Tel: 01903 737756
Email: planning@arun.gov.uk
www.arun.gov.uk/planning
Please ask for: Mrs D Johnson
Email: daun.johnson@arun.gov.uk
Telephone: 01903 737762
Our Ref: P/158/25/CLP
Your Ref:
Date: 15th December 2025

Lawful Development Certificate for a Proposed Use or Development

Development: Lawful development certificate for a proposed infill extension between garage and main house.
Location: 5 Church Lane Pagham PO21 4NS

PART GROUND FLOOR
PLAN. [AS EXISTING.]
1:50 @ A3.

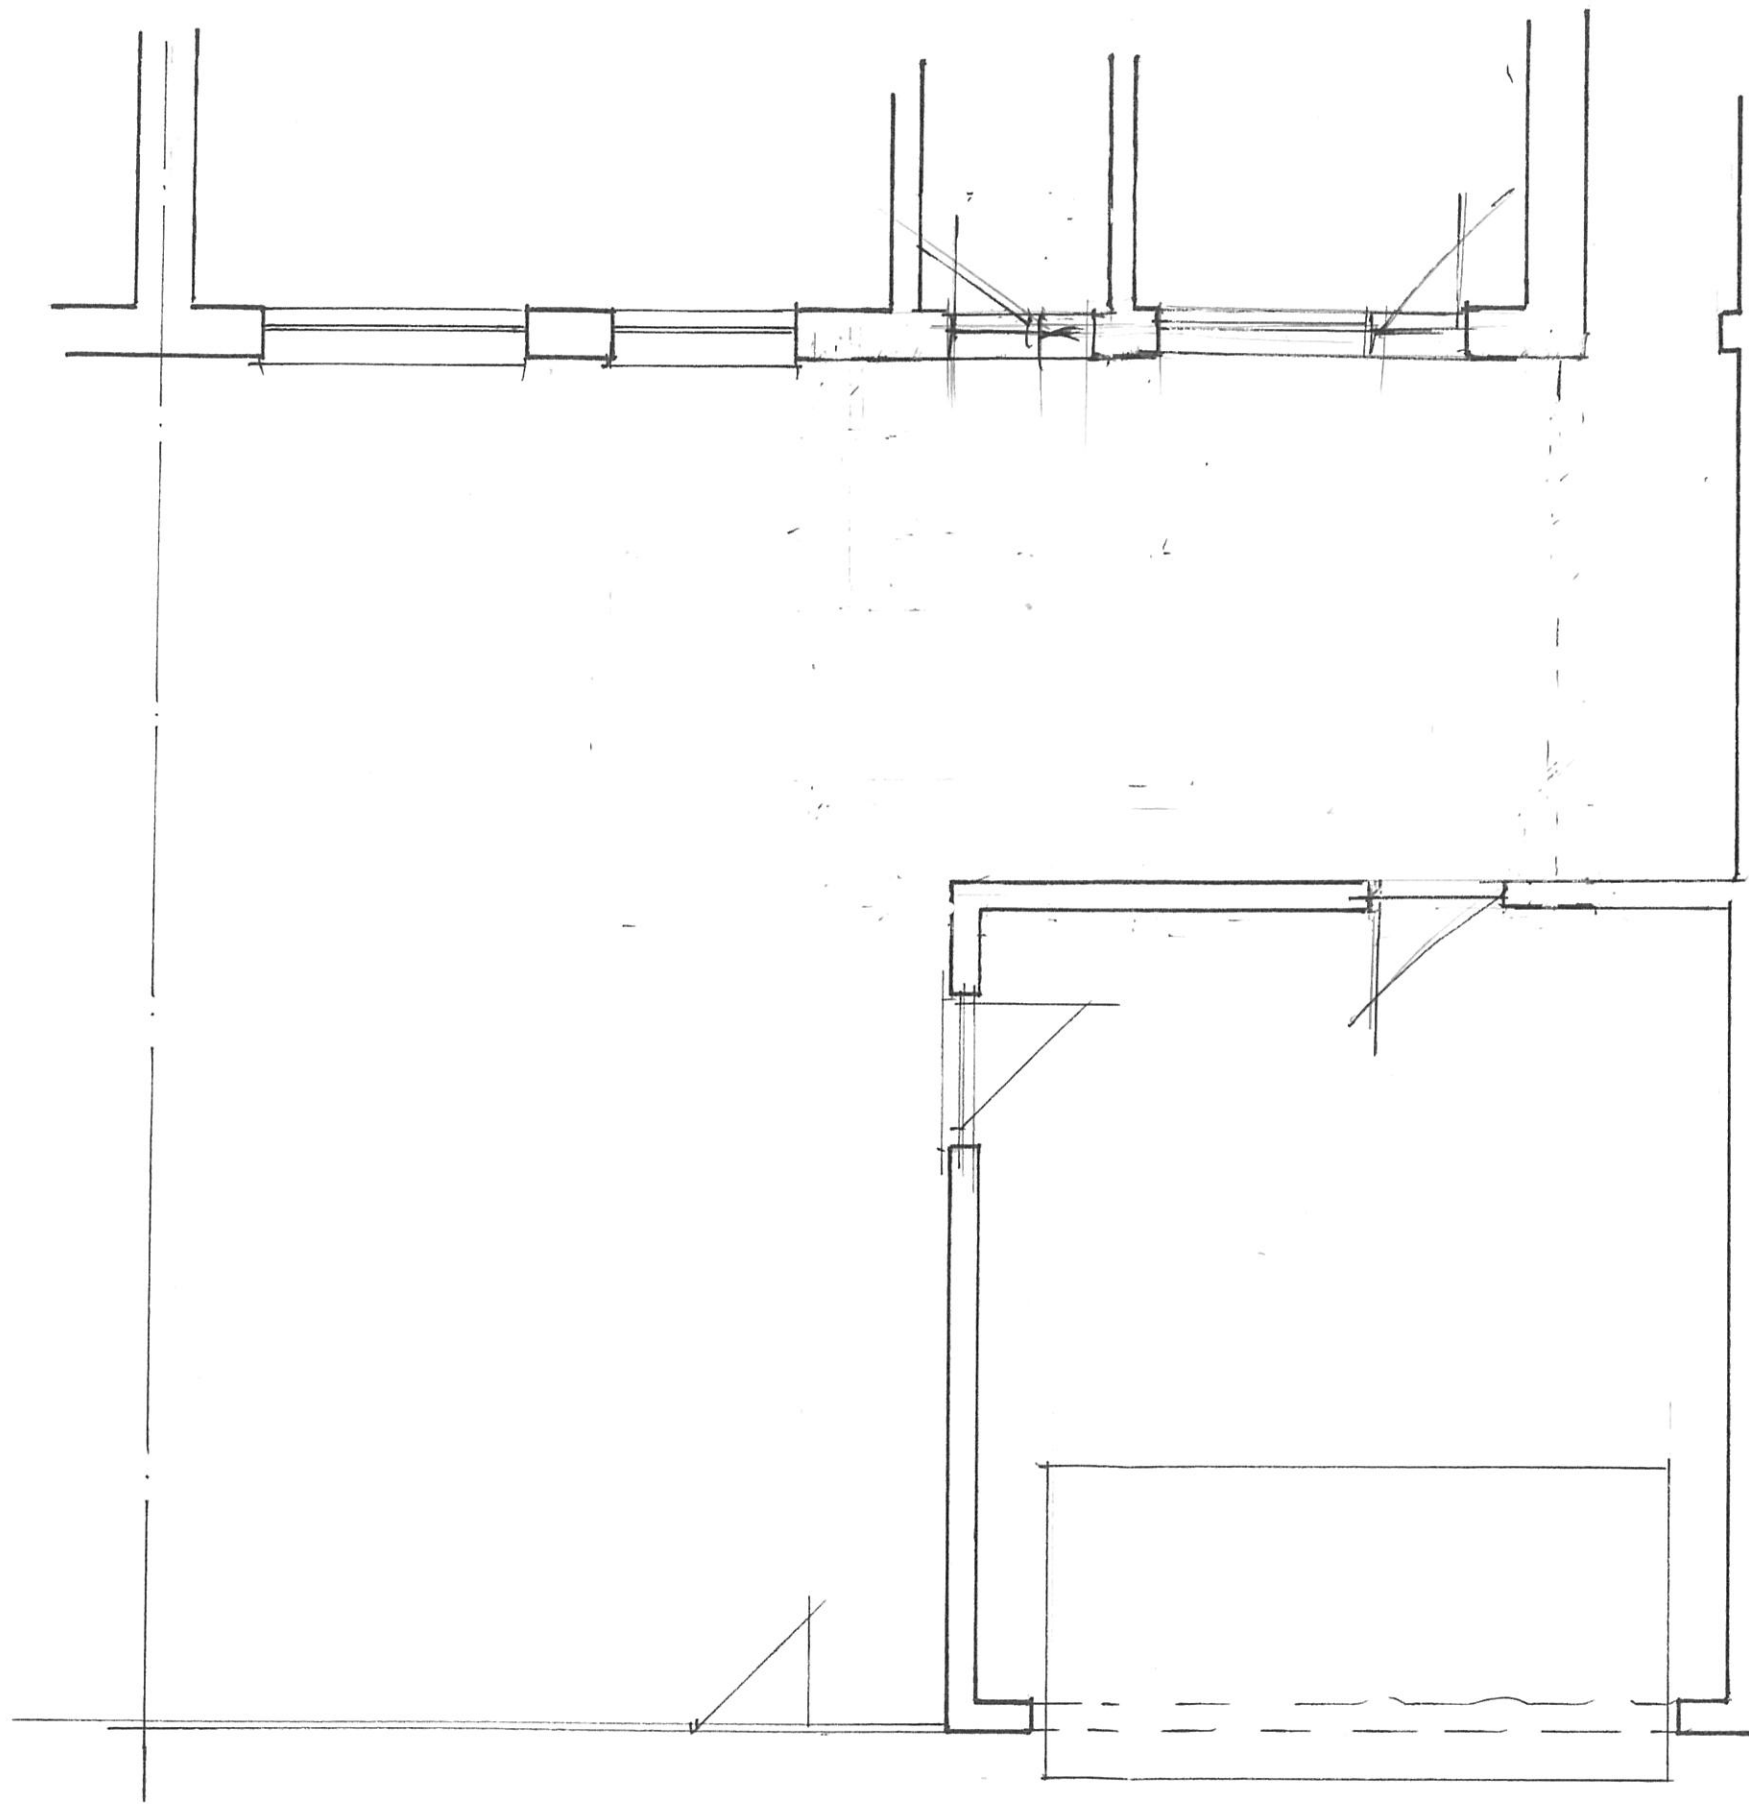
Please provide an existing floor plan.

The existing and proposed north elevations and floor plans do not accord. Please amend accordingly.

The existing and proposed east elevations and floor plans do not accord. Please amend accordingly.
